Loreto Kirribilli – Western Precinct

PRELIMINARY BCA ASSESSMENT

REPORT 2016/1744 R1.4

Loreto Kirribilli – Connectors to Northern, Eastern and Southern Precinct

# Southern Precinct Connector

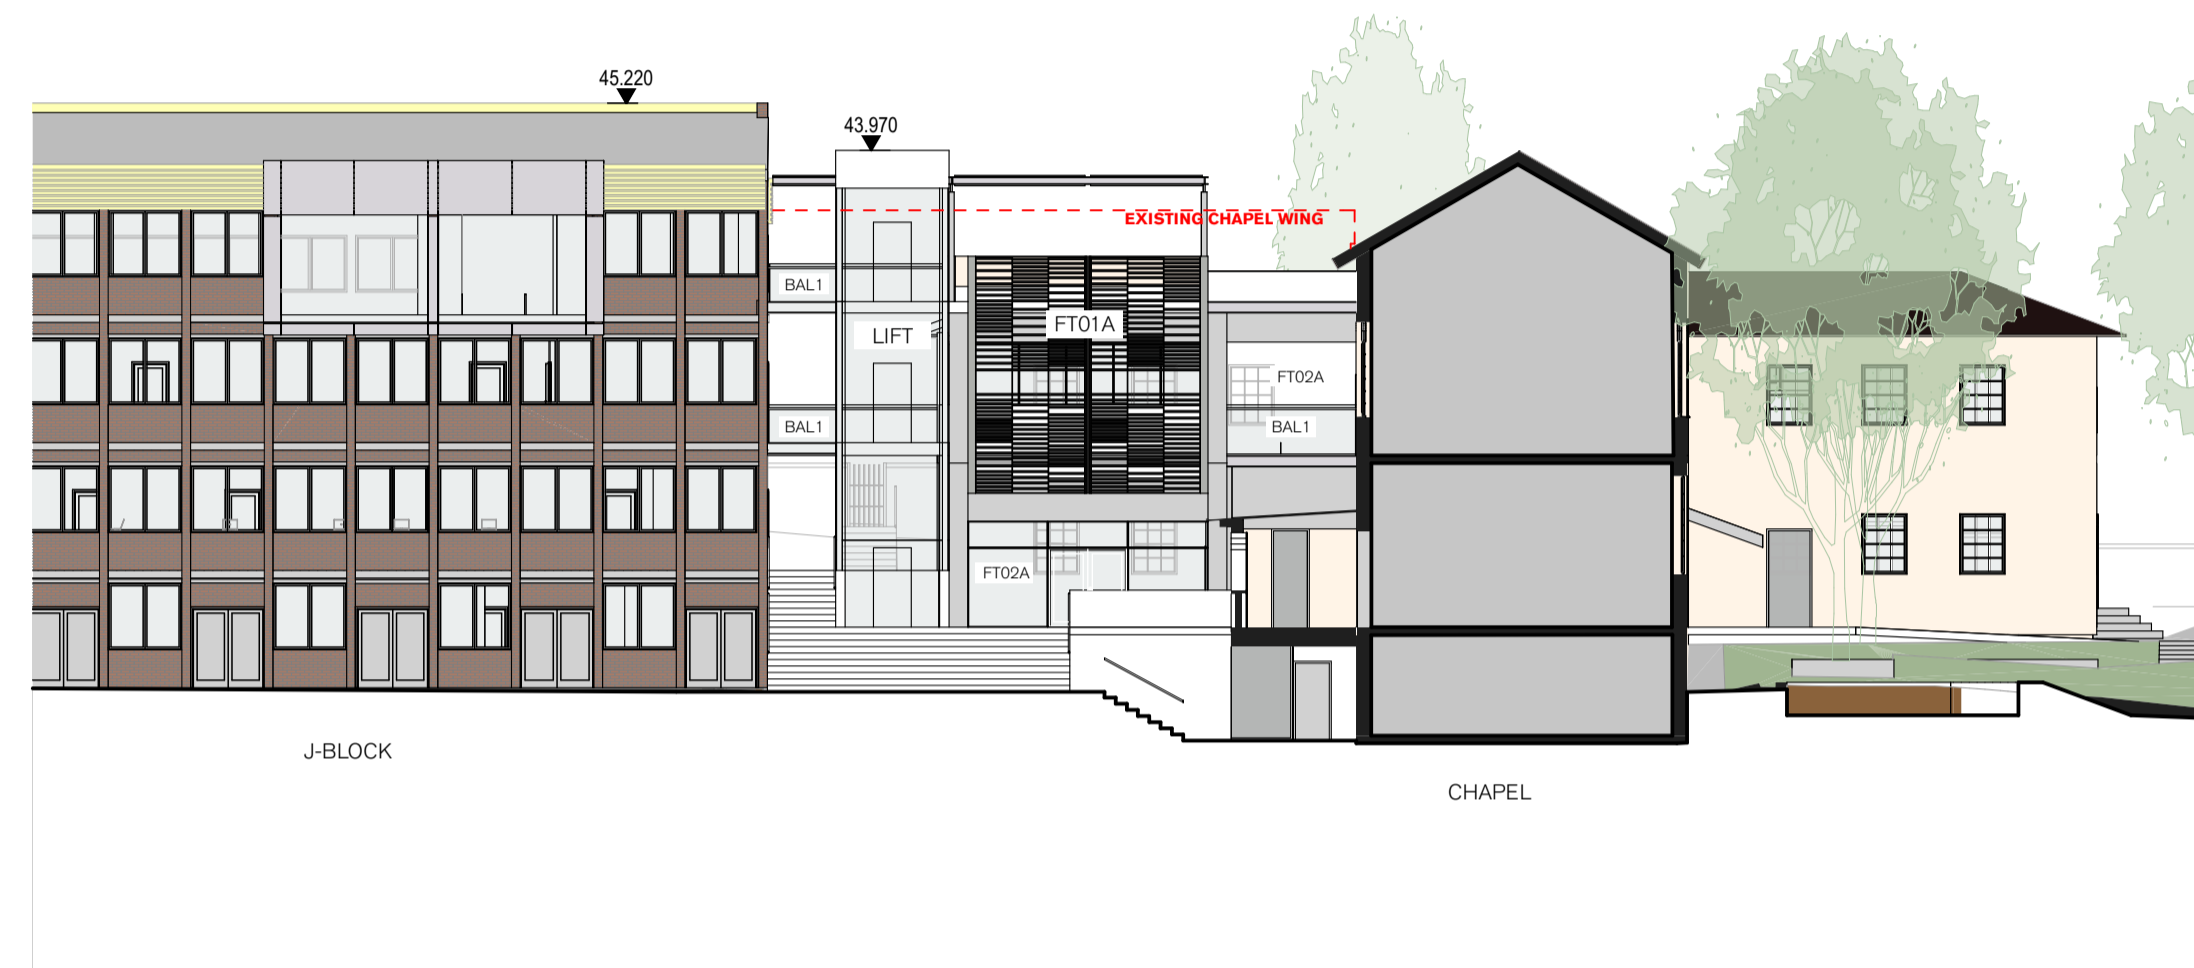
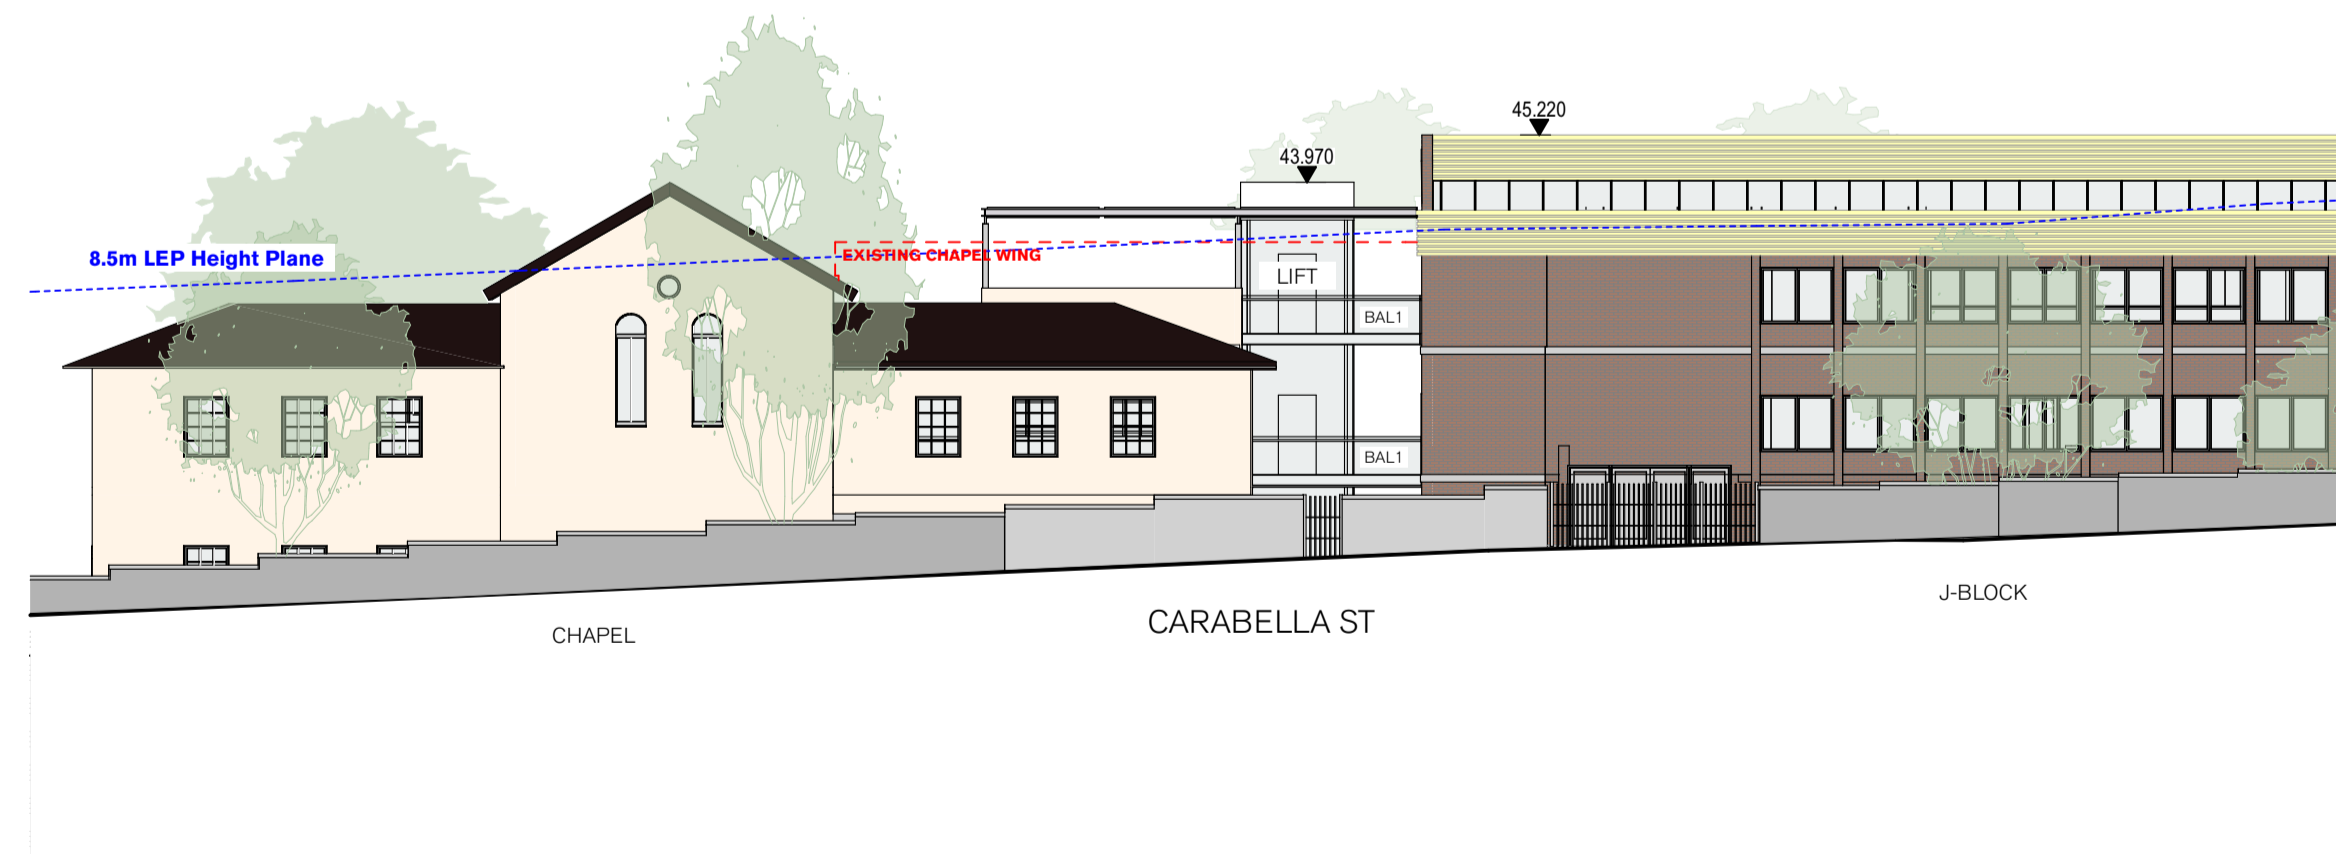
- The J-Block, Chapel and Elamang buildings are considered to be united buildings as they are connected by a series of bridge links and other openings.
- Any new structure is generally required to achieve a 2hr FRL i.e. floors, columns, beams and other loadbearing elements
- As the building is required to be erected to Type A construction, vertical separation of openings in external walls is required with spandrels. The spandrel must be a minimum 900mm in height and extend no less than 600mm above the upper surface of the floor. Extract from the guide to the BCA detailing compliant spandrels shown below.

Spandrels will need to be provided to the external walls of the new connector. They will also be required to the new balcony pods. Additional details of the proposed spandrels are to be provided prior to the issue of the CC

- A lift connecting more than 2 storeys is required to be in a fire resisting shaft achieving an FRL of -/120/120. The proposed lift connects/passes by 5 storeys and therefore should be in a fire resisting shaft in accordance with Clause C2.10. Should a glass lift be proposed, a fire engineered solution will be required to be investigated to determine if it can be achieved on a performance basis.
